## 13 Air quality

### 13.2 Response to submissions

Figure 3.1

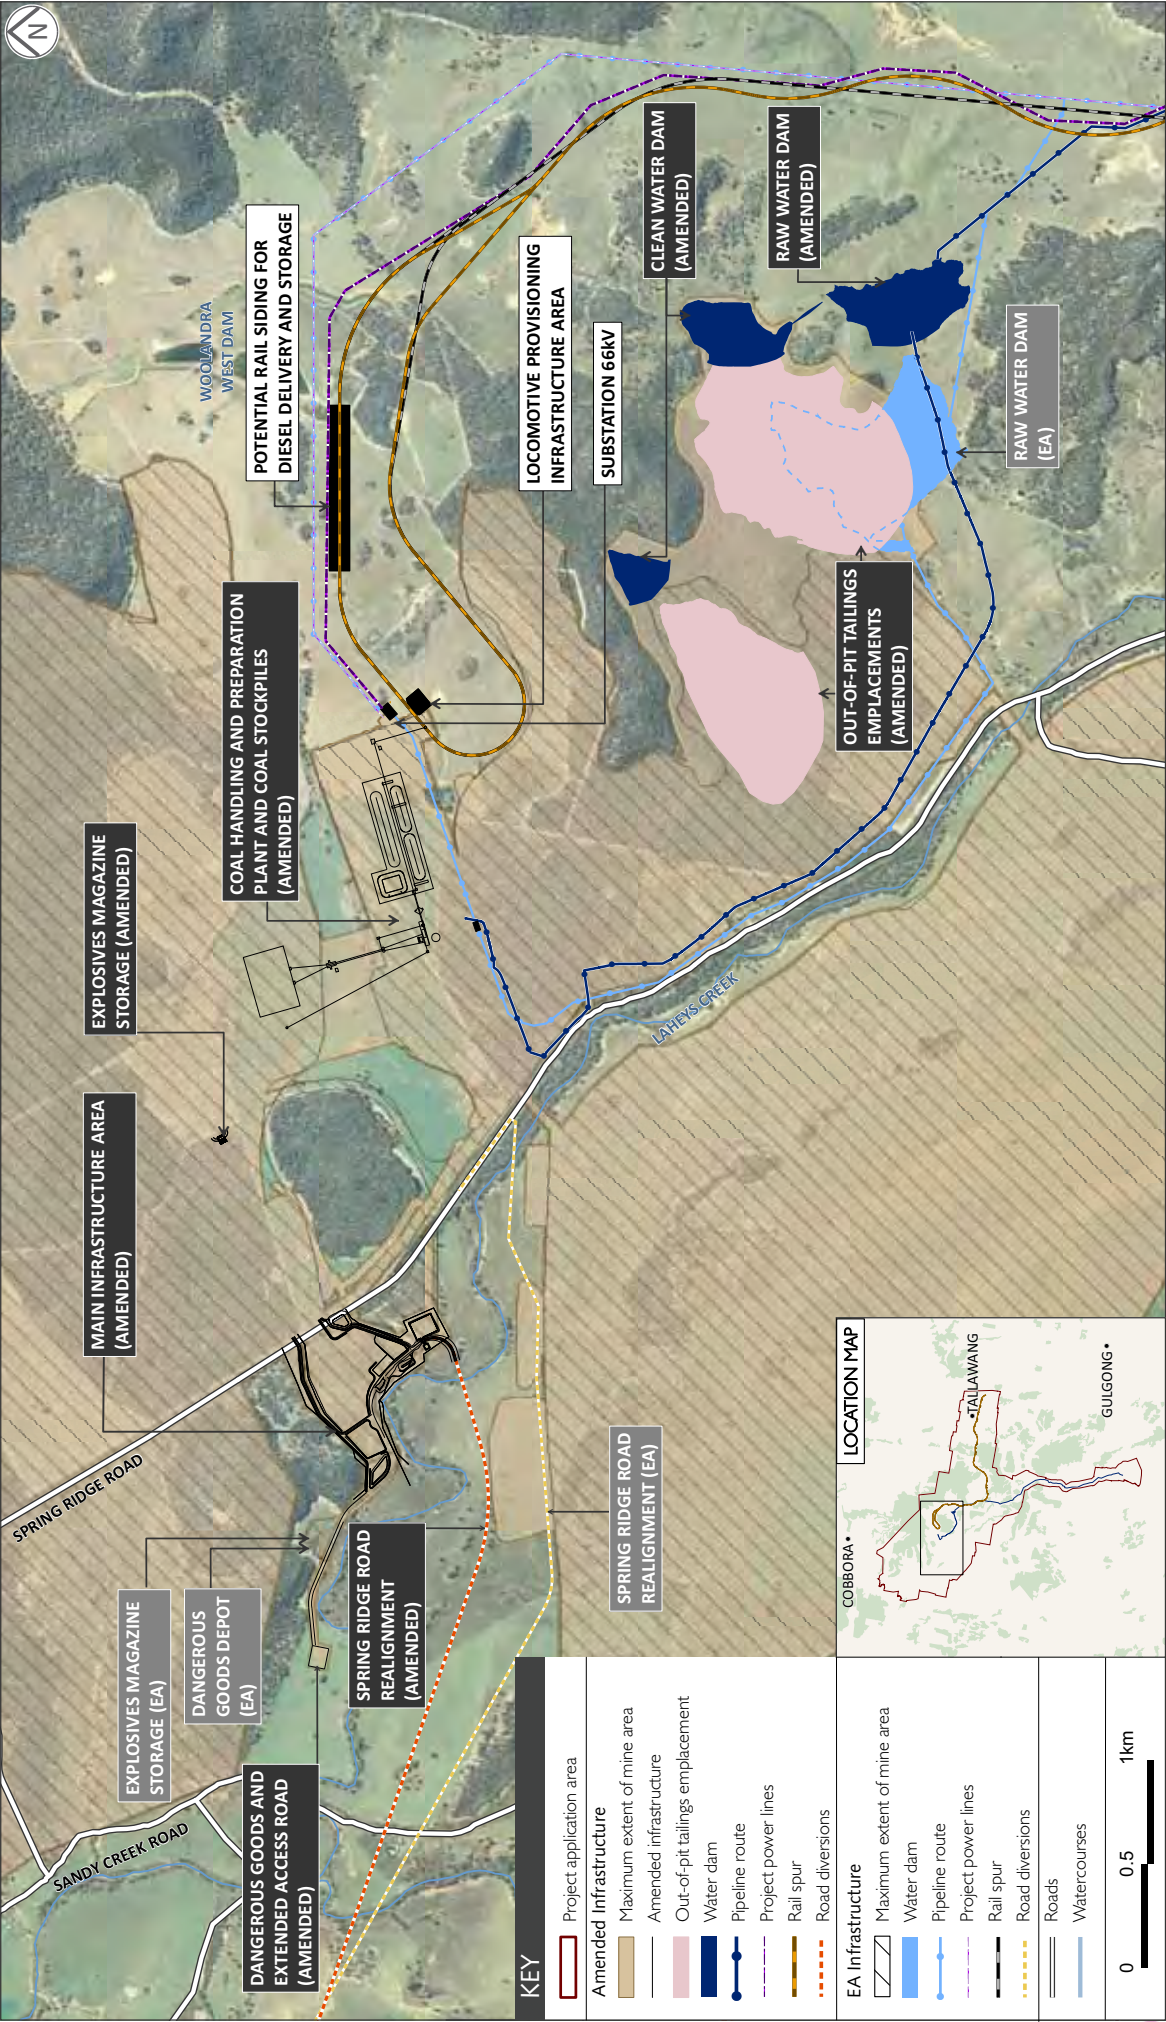
This submission asks, “Figure 14.1 Air Quality Assessment Locations indicates an area of Maximum extent of Mine, does this include stockpile areas for overburden and topsoil?”.

The out-of-pit waste emplacements are in the maximum extent of mine area shown in the main EA (Figure 14.1). This can be seen by comparing main EA figures 1.2 and 3.1, which show maximum mine extent and out-of-pit waste rock emplacements. An updated mine layout is provided in Figure 3.1 and, as described in Section 13.1, changes to the Project will not change air quality impacts.
